Recommendation Report for Planning Permission

REF NO: FP/61/20/PL

LOCATION: 10 Felpham Gardens
Felpham
PO22 8QS

PROPOSAL: Demolition of 1 No. house & erection of 2 No. chalet style dwellings with garaging & car parking (resubmission following FP/274/18/PL).

PROPOSED PLOT PLAN

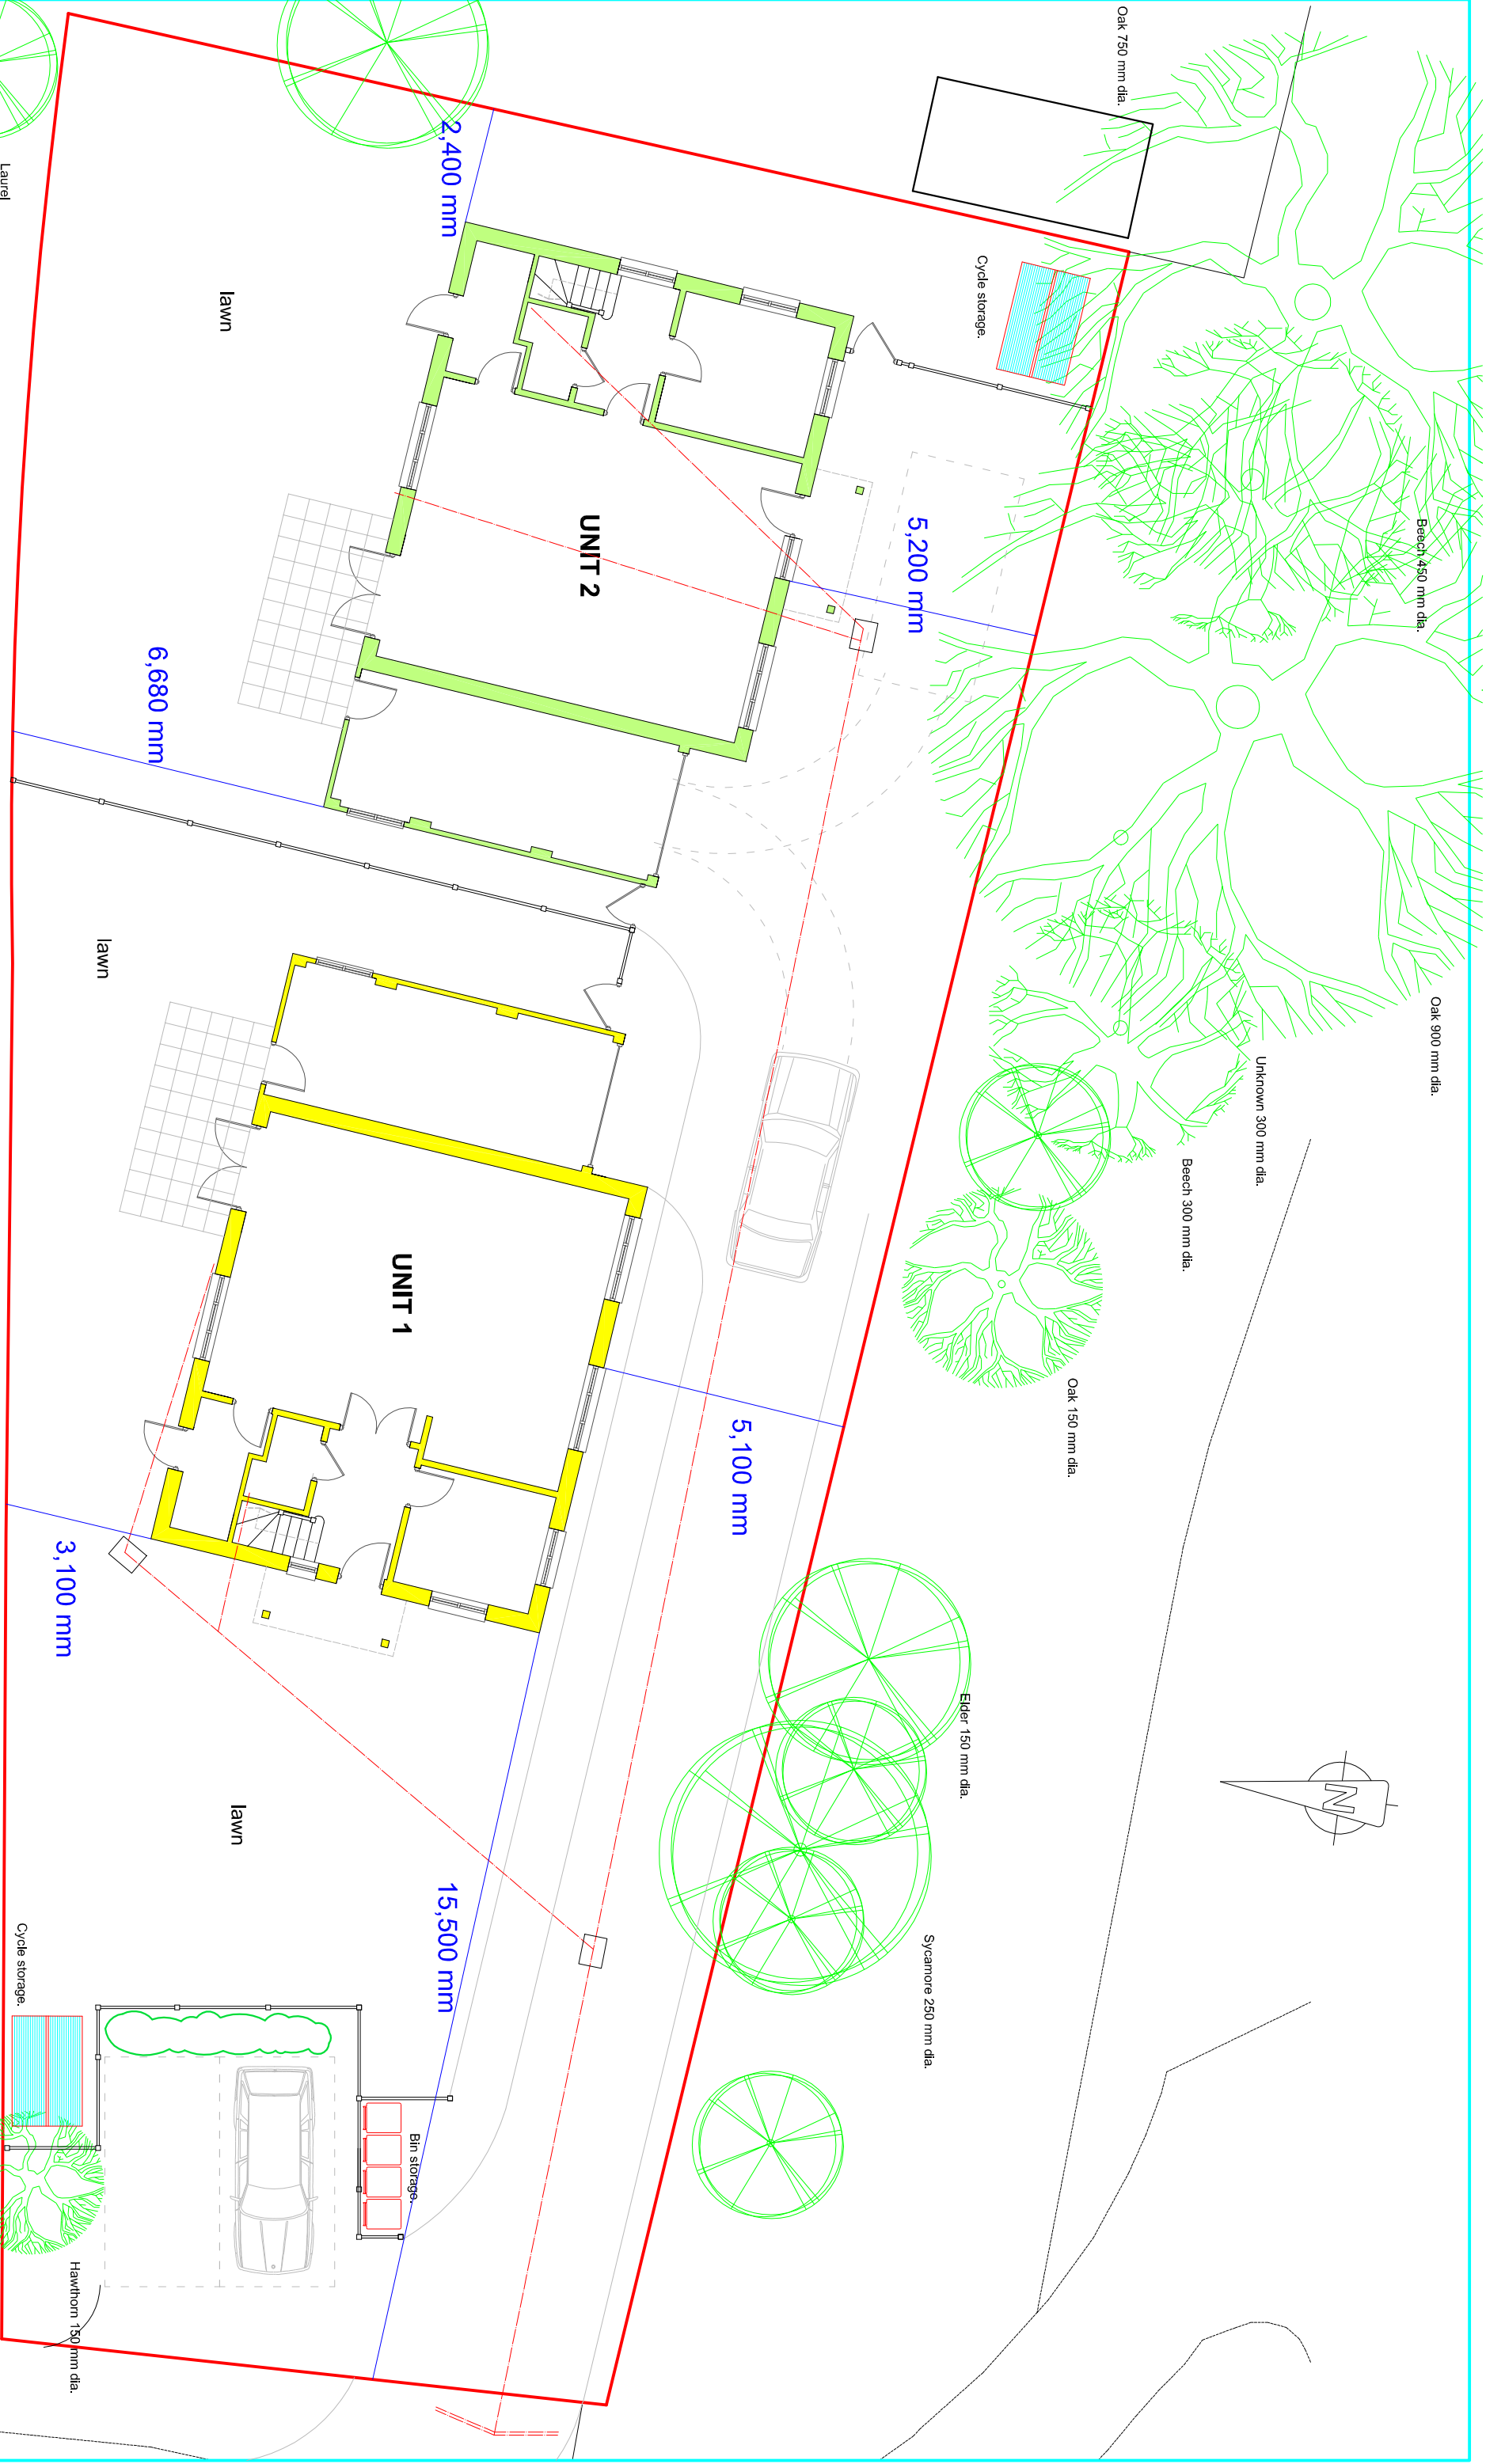
The direction of units' layout, within the plot of an irregular shape, would be rotated and would be aligned with the southern boundary.

Unit 1 would be well set back from the front boundary by approximately 15.5m, set in from the shared boundary with No 8 Felpham Gardens by 3.1m.

Unit 2 would be sitting behind Unit 1 within a separation distance of 3m and would be a mirror picture of it. Eastern flank elevation of Unit 2 would be within a distance of 2.4m from the shared boundary with West Corner, a bungalow at Clovelly Avenue (cul de sac) to the east and would be set in from the shared boundary with No 8 Felpham Gardens by 6.68m.

Due to the back land form of the proposed development Unit 2 would not have any active street frontage. Whilst it would not be particularly visible from Felpham Gardens its flank elevation will appear alien when seen from the end of Clovelly Avenue.

The application site would be accessed via the existing dropped kerb and access point off the east side of Felpham Gardens, and would run along the southern boundary of the site, leading to both garages and 1 No. parking space to the front of Unit 2. There would be an additional 2 No. parking spaces to the front of the site; resulting in a total of 5 No. parking spaces. Secure, covered cycle parking provision is provided to the front of the site and to the rear.

The proposed dwellings would provide a significantly smaller area for external amenity space than the existing dwellings within Felpham Gardens, which indicates an overdevelopment of the site. Provided private garden for Unit 1 is extremely small, however given the close vicinity of the open green space to the south it is considered that the scheme provides an acceptable standard of amenity for future occupiers.

PROPOSED ELEVATIONS
UNIT 1

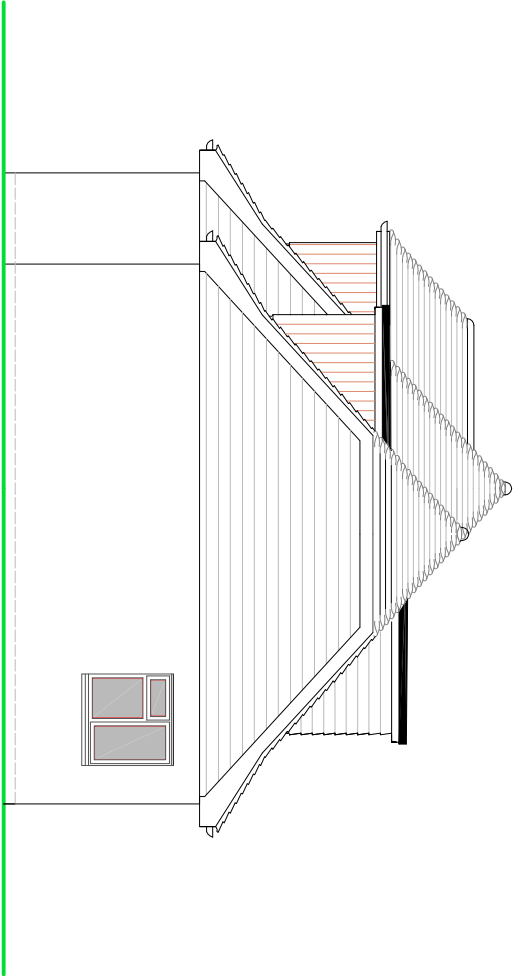
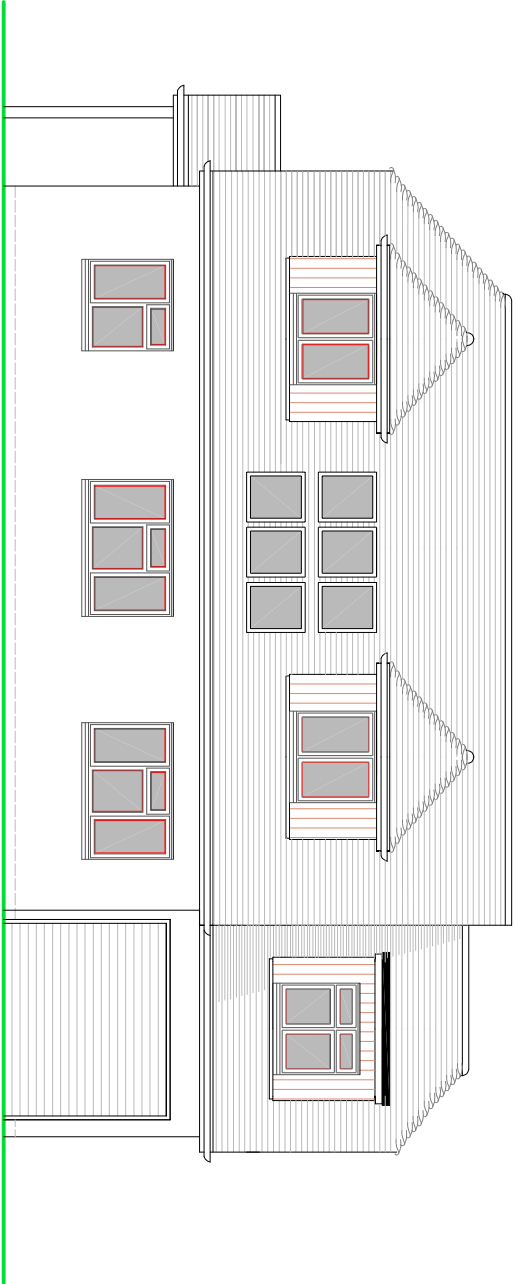
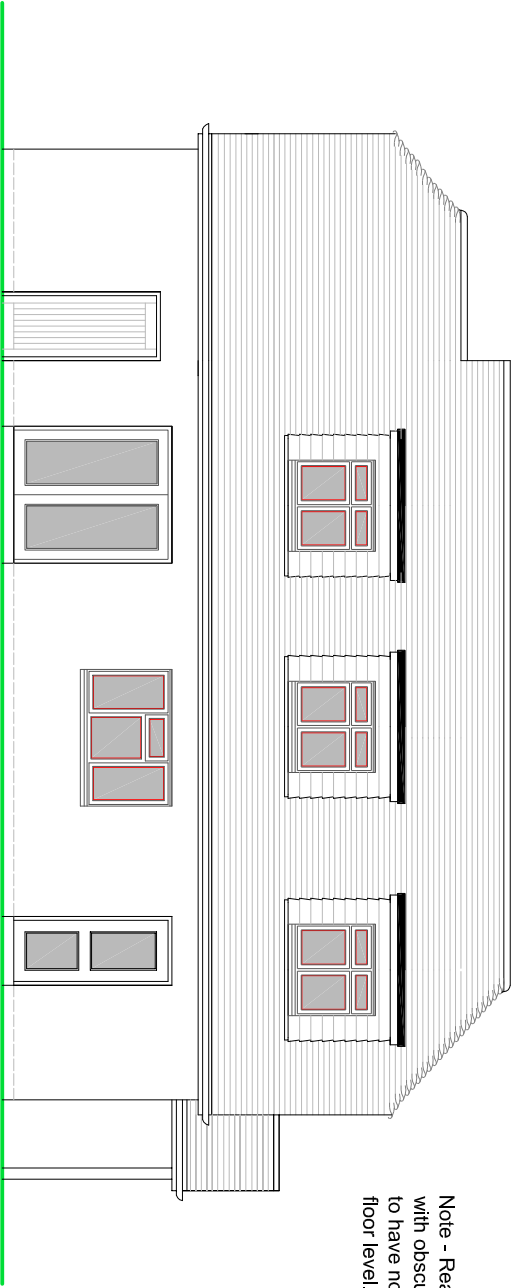
In addition, half hipped roofs as proposed are not found within Felpham Gardens where houses share a common architectural language, giving a fairly uniform character and appearance. Therefore the mix and match approach in this proposal would create a cluttered development, that would fail to sit comfortably within surroundings.

PROPOSED ELEVATIONS

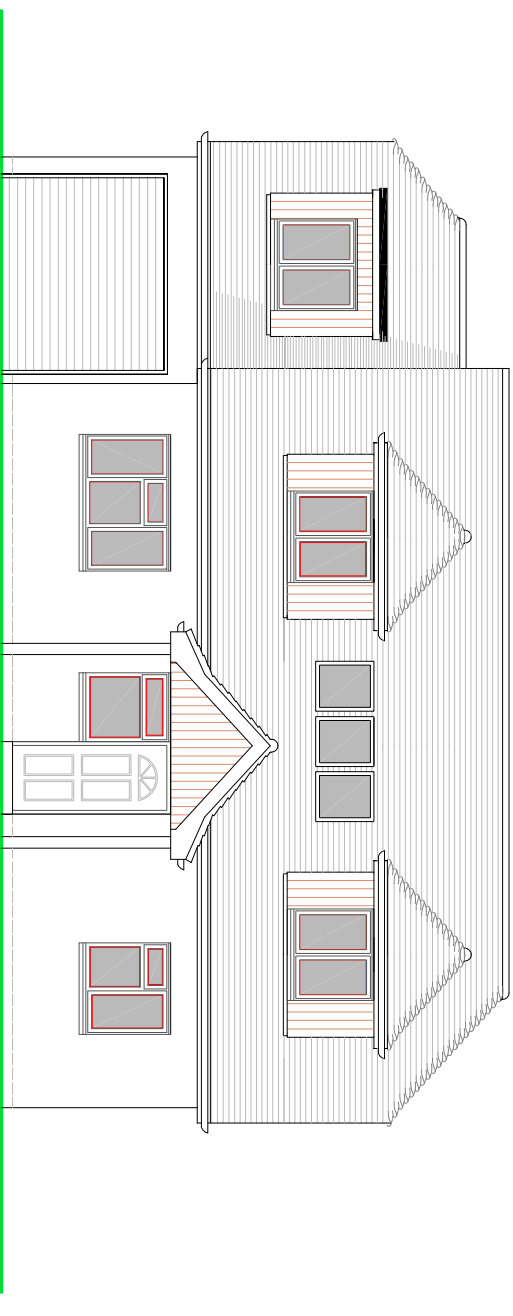
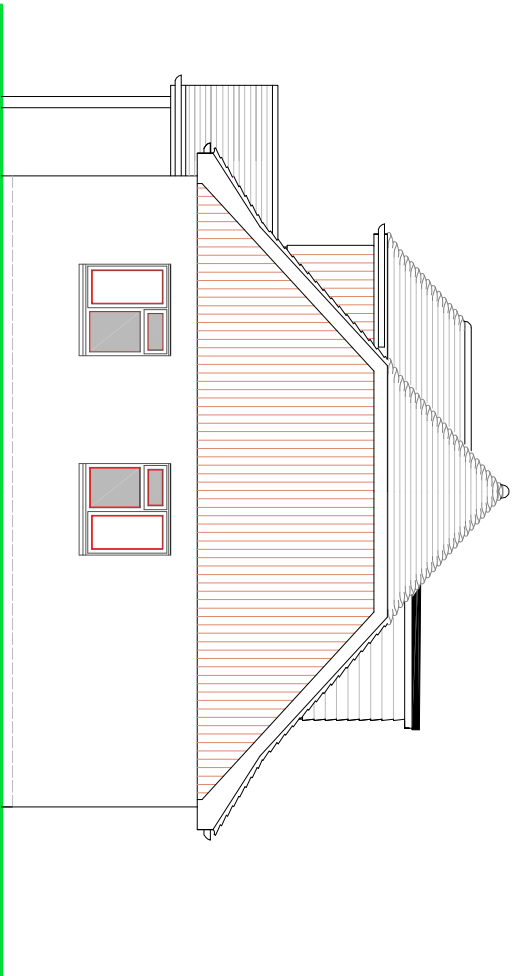
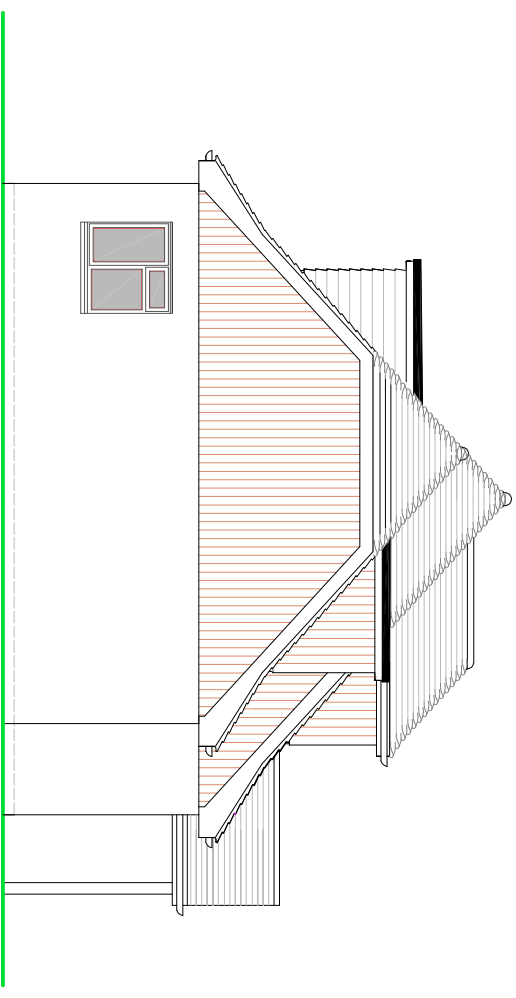
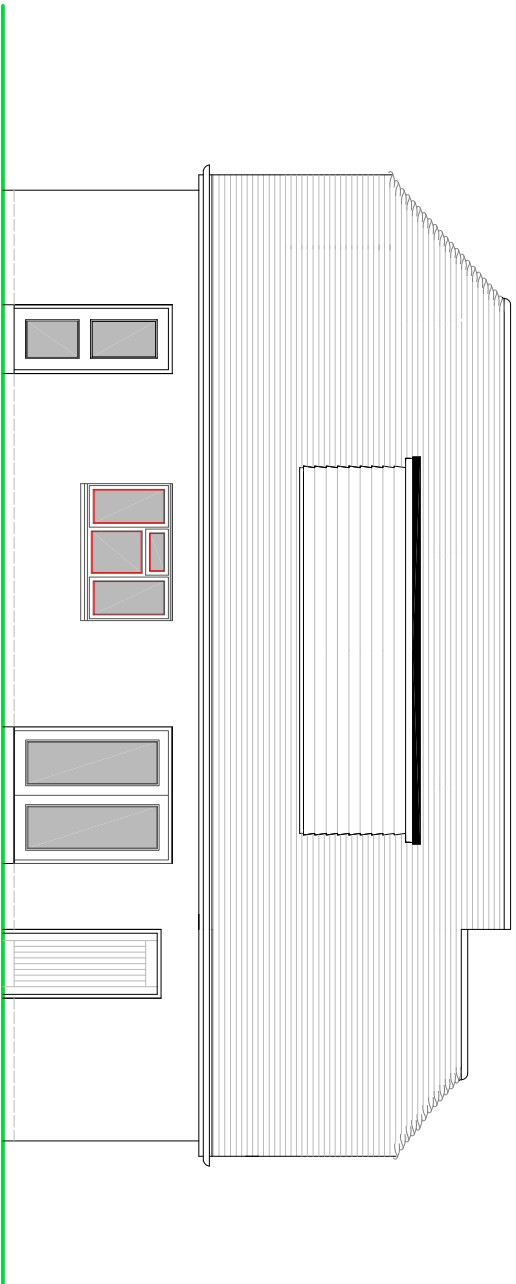
The proposed new dwellings, especially Unit 2 due to its position and massing would have impact on living conditions of No 18 Felpahm Gardens and West Corner in the end of Clowely Avenue cul de sac, limiting their outlook and resulting in an overbearing feel of a substantial building in close proximity to their rear garden.

The northern elevation of the proposed Unit 2 would appear oppressive, exposing bulky roof structure with one large windowless dormer. Whilst this would maintain the privacy of neighbouring dwellings/gardens it would result in an unneighbourly development which would in addition block the open view at the King George V Field to all users of rear gardens of dwellings along the eastern side of Felpham Gardens.
